From: Sarah Burrow <Sarah.Burrow@arun.gov.uk>
Sent: 18 May 2022 12:26
To: Planning.Responses <Planning.Responses@arun.gov.uk>
Cc: Obafemi Okusipe <Obafemi.Okusipe@arun.gov.uk>
Subject: RE: Planning Consultation on: M/151/21/PL

Engineers Comments Regarding Surface Water Drainage

Site Address: 7 Central Drive Middleton-on-Sea PO22 7TT

Description of Works: Erection of 1 No. 4 bed dwelling (resubmission of M/105/18/PL). This application is in CIL Zone 4 and is CIL liable as new dwelling.

DRAINAGE LEGEND (1:100)
PROPOSED FEATURES

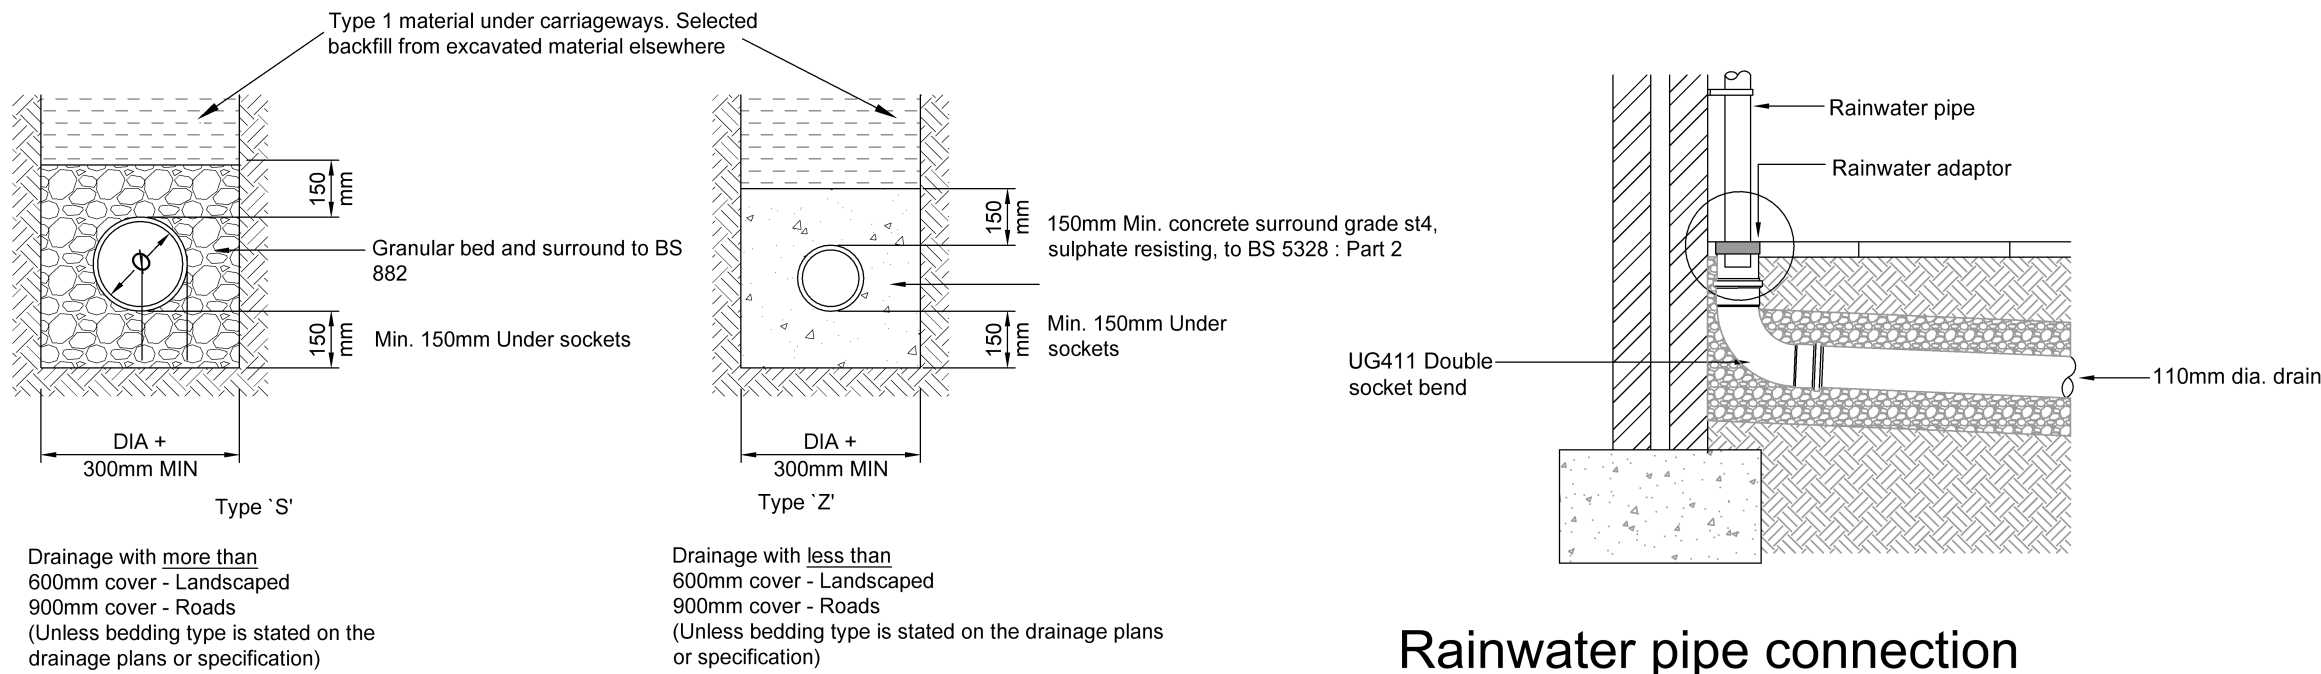
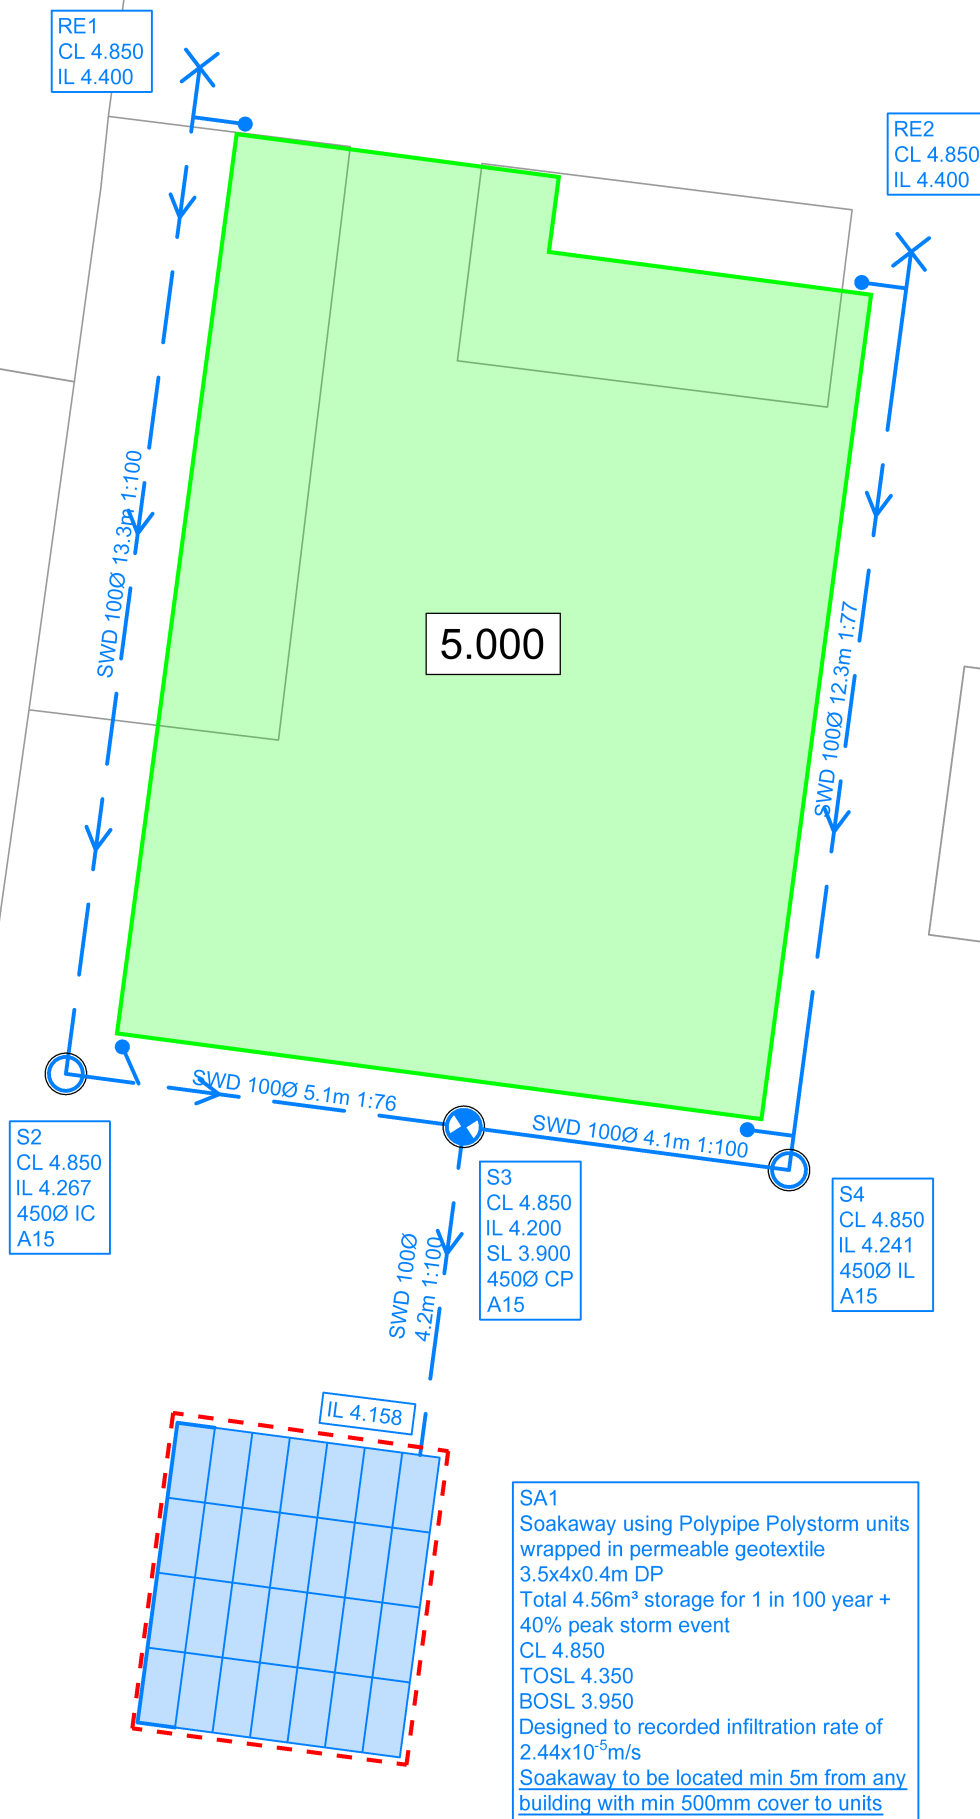
1. The proposed soakaway appears to be located on the proposed boundary with 7 Central Drive, this is not appropriate as it could be placed in close proximity to any soakaways for the existing dwelling. Please relocate the soakaway at least 2.5m from the proposed boundary.
2. S2 is located after a bend in the pipe at the south east corner, please relocate this so that the bend is removed.
3. Please include the invert level of the entry pipe to the soakaway, this must be located above the 1 in 10 year +40% water level.

Trench soakaway using Polystorm Lite Geomodular units

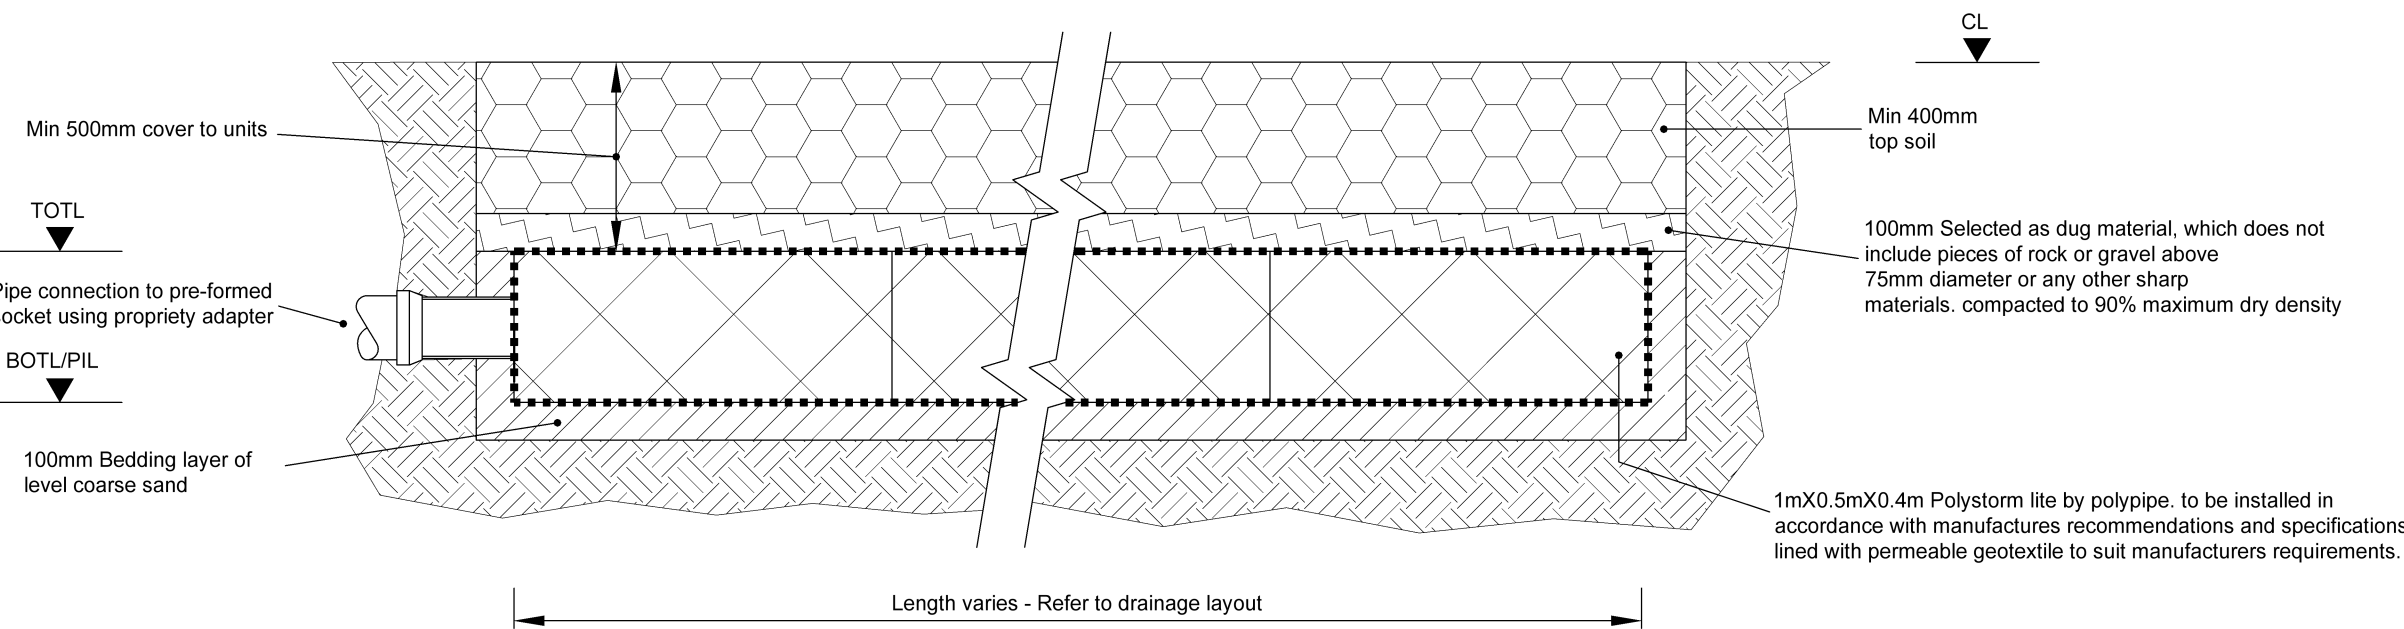
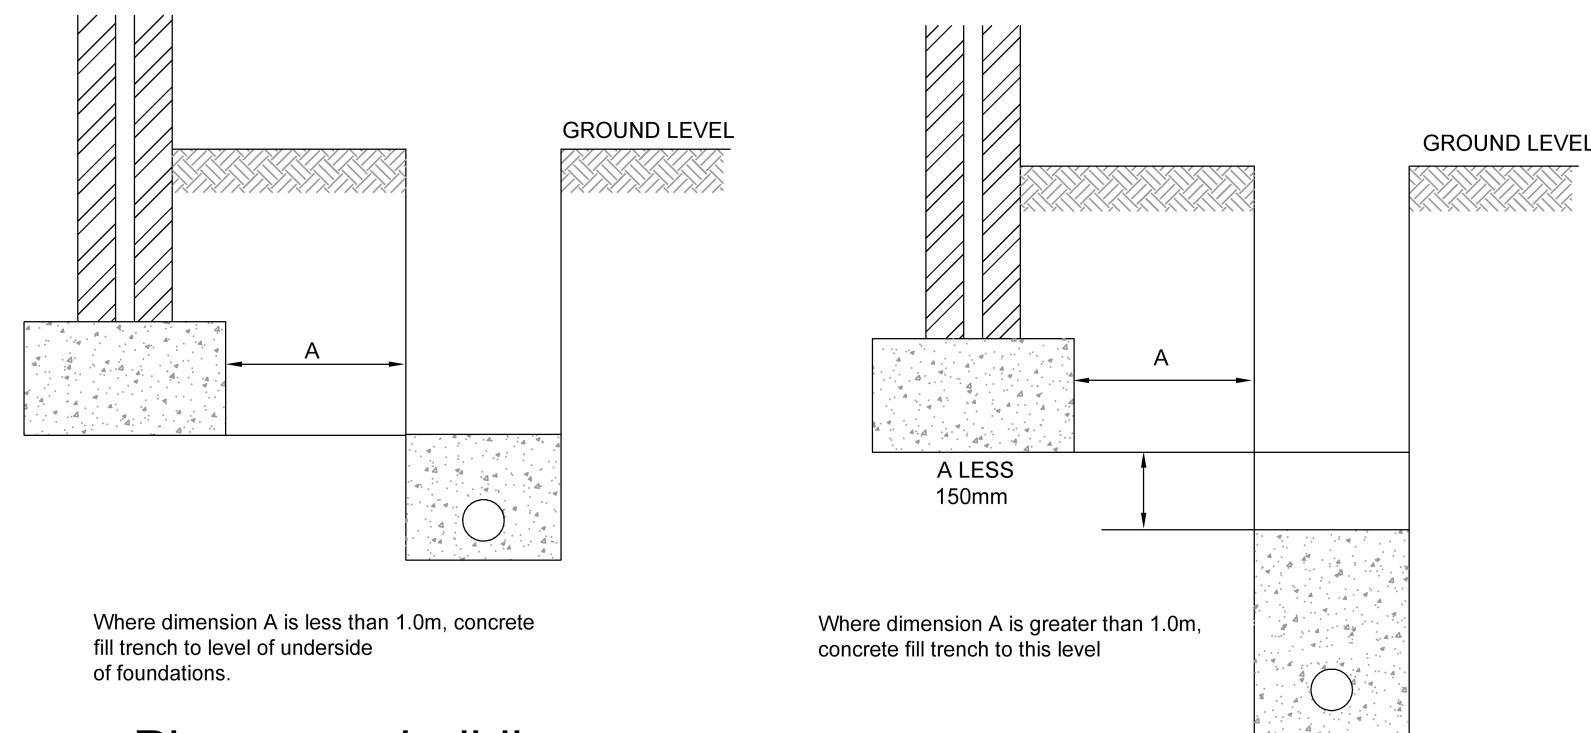
4. Infiltration rate should be supplied to base or sides of the soakaway not both, particularly given that the groundwater monitoring period was short – thus increasing risk.
5. Please include a construction detail of the vents for the soakaway with the drawings.
